# CITY OF ALBUQUERQUE

**Re: Mitchell Elementary School Cafeteria Addition Grading and Drainage Plan  
Engineer's Stamp date 06-27-2012 (G-21/D033)**

Based upon the information provided in your submittal received 06-26-12, the above referenced plan cannot be approved for Building Permit until the following comments are addressed:

CG-101

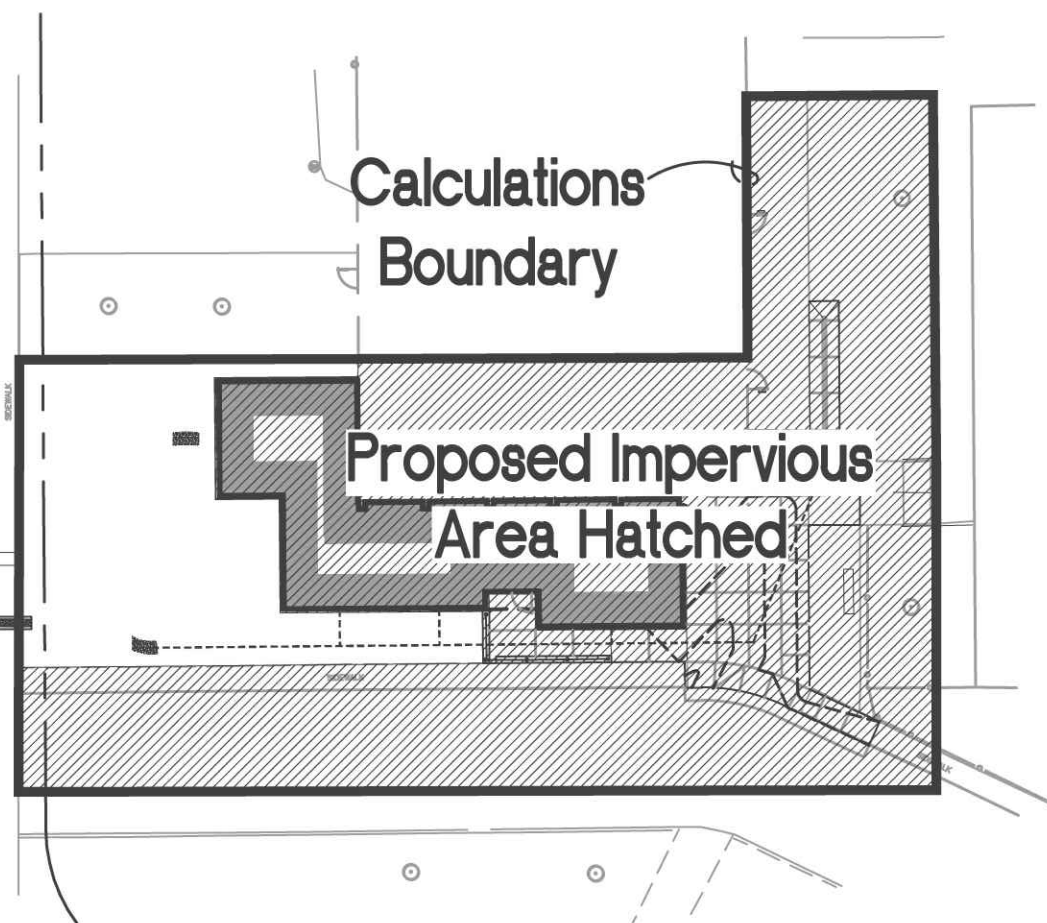
- Please show the property line along Inca Street; the sidewalk culvert should extend two feet east from back-of-sidewalk on Inca.
- Provide culvert capacity calculations for the proposed sidewalk culvert.
- Note #2 under the "SO-19: Notice to Contractor" table should be revised to Update #8.
- It appears that the western-most proposed contour was intended to be at an elevation of 5568 feet, not 5569.
- Depress landscaping for water harvesting and to help mitigate the increased discharge due to the new development on site.
